Millbrook Power Limited: Proposed gas fired power plant at Rookery South Pit, Nr. Millbrook, Bedfordshire

In accordance with the programme set by the Examining Authority (ExA) in the Rule 8 letter published on 20 March 2018, Millbrook Power Limited (the "Applicant") encloses for Deadline 5:

Non Material Amendment

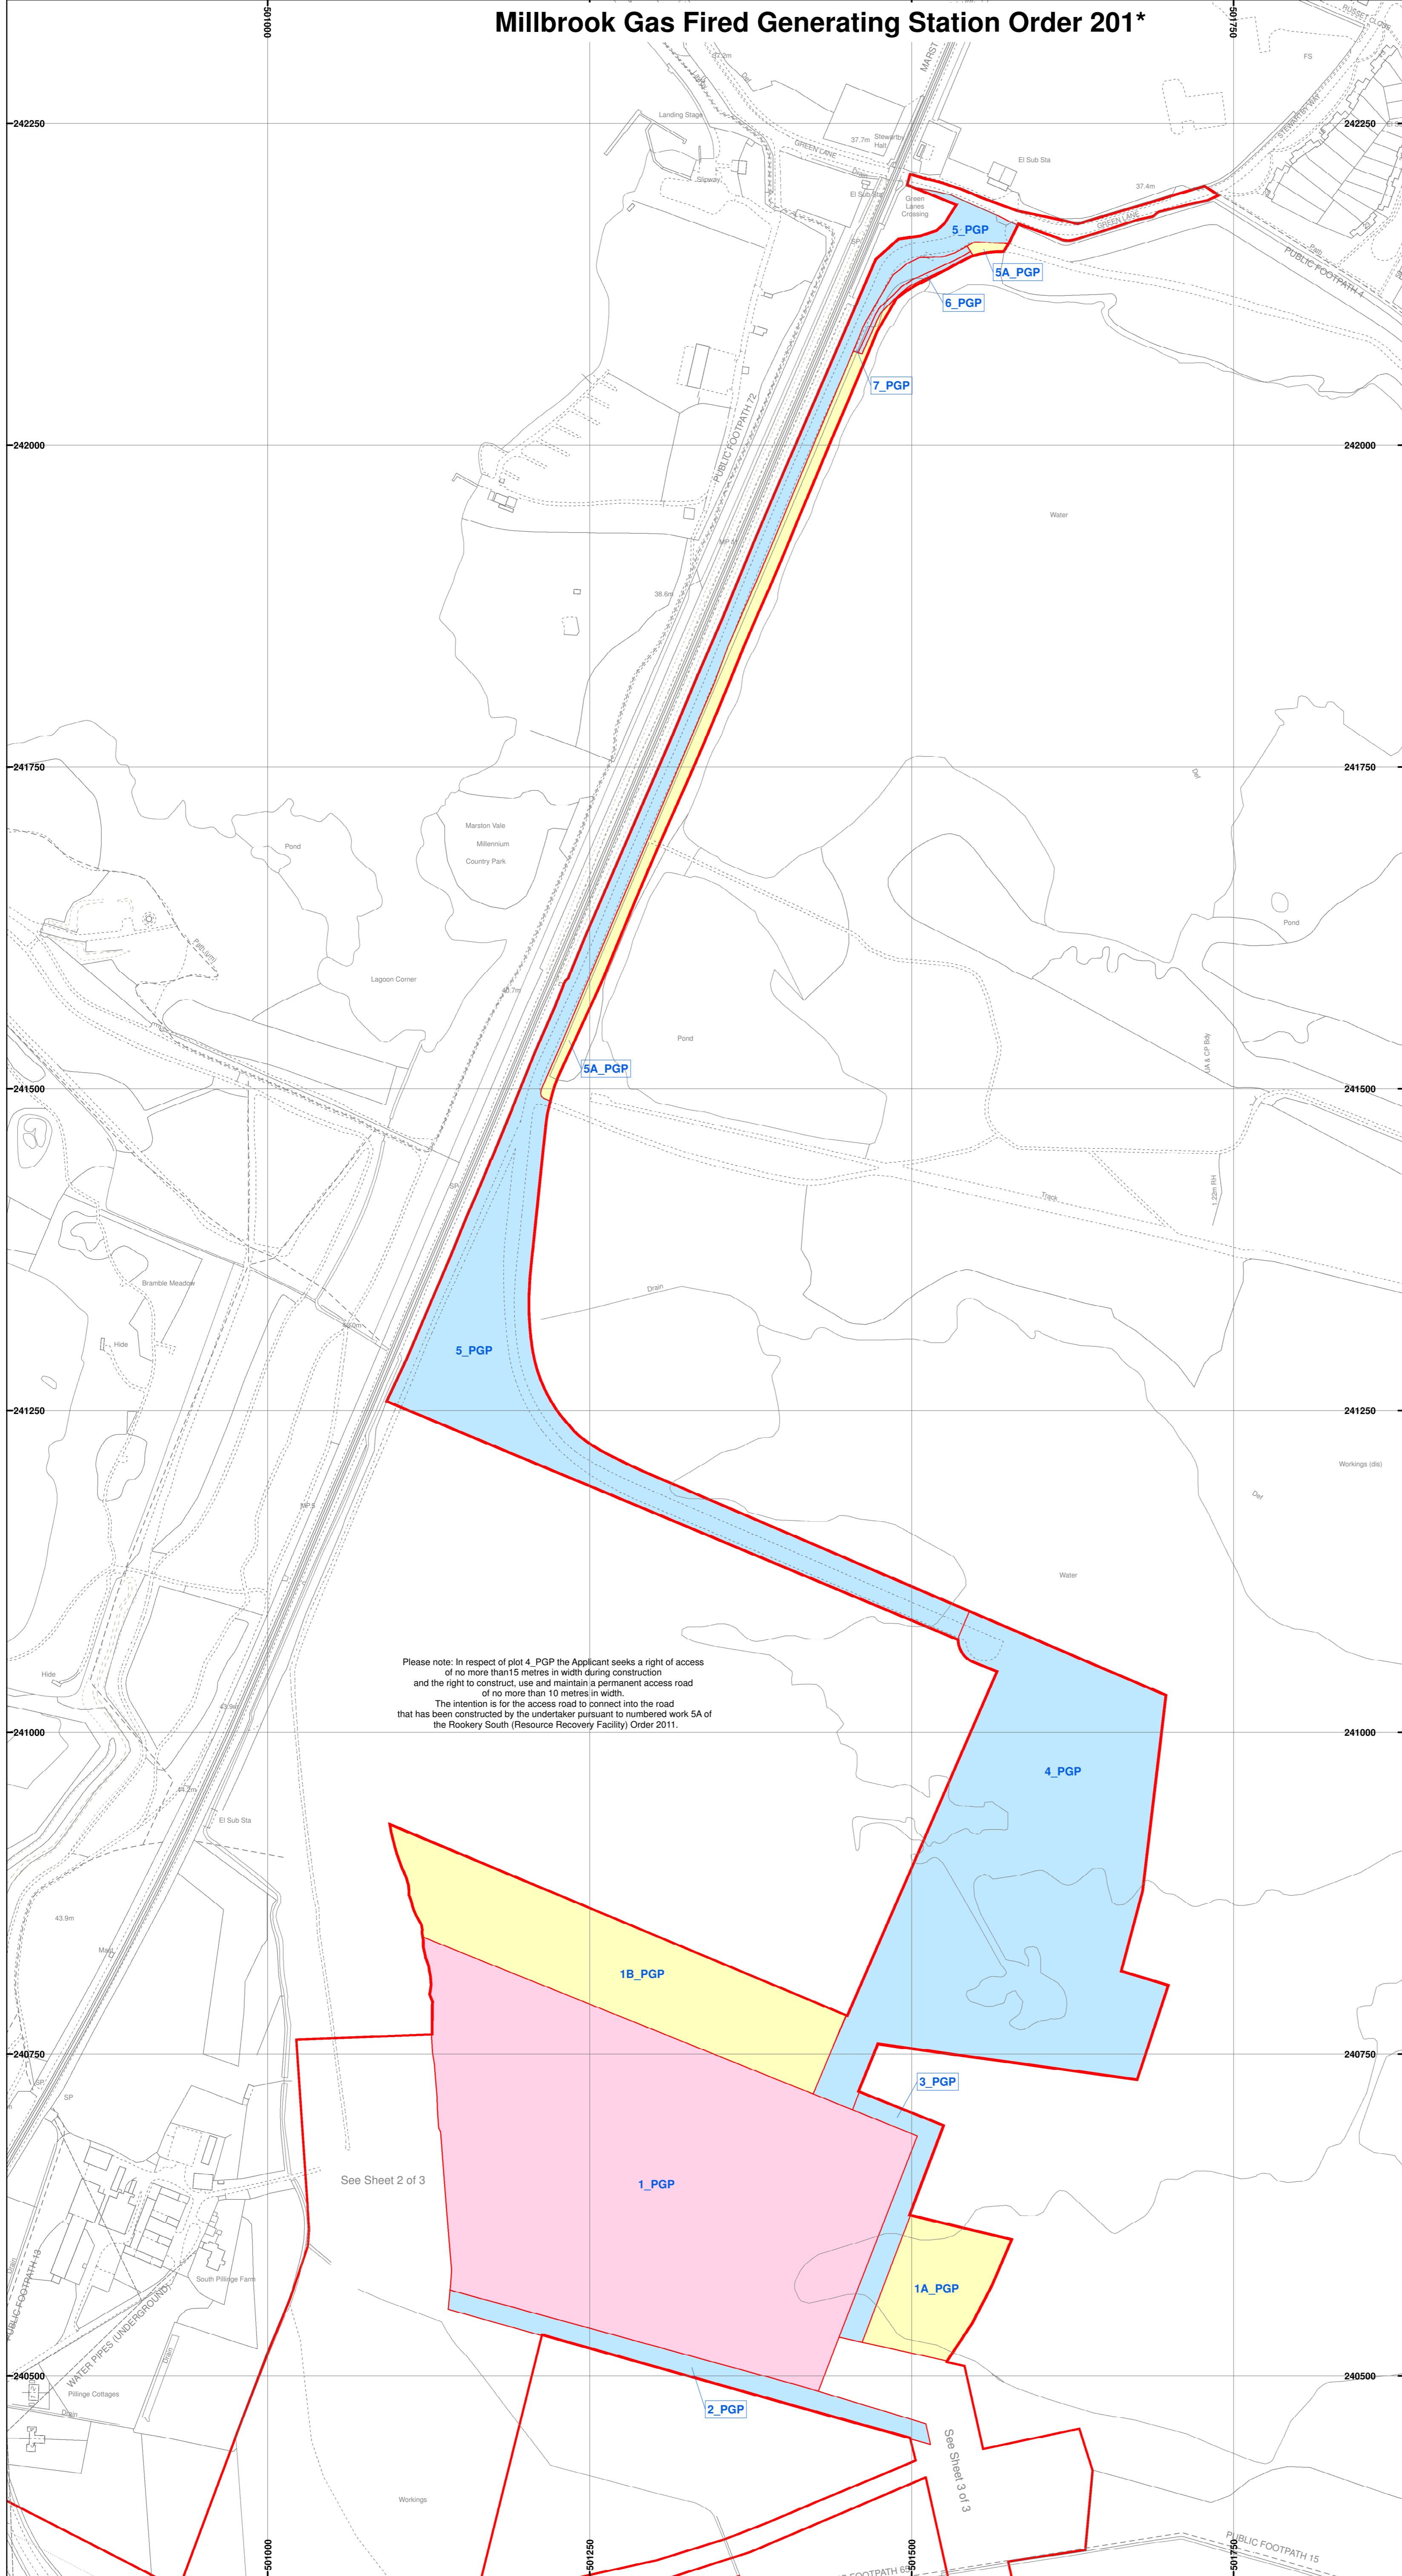
The Applicant has made it clear throughout the Examination that it would amend the Order limits and reduce the extent of plot 4_PGP in the event that the access road was constructed by Covanta pursuant to numbered work 5A of the Rookery South (Resource Recovery Facility) Order 2011.

The access road has now been completed (with the exception of the creation of a new junction with Green Lane) and the Applicant is now acting on its intention as set out in the Application documents, at the Examination Hearings and in responses to the Examining Authority's written questions. Accordingly, the Applicant requests that the Examining Authority accepts the proposed non-material amendments to the Order limits and plots 4_PGP and 5_PGP and the related amendments to the extent of numbered work 2A in Schedule 1 of the DCO.
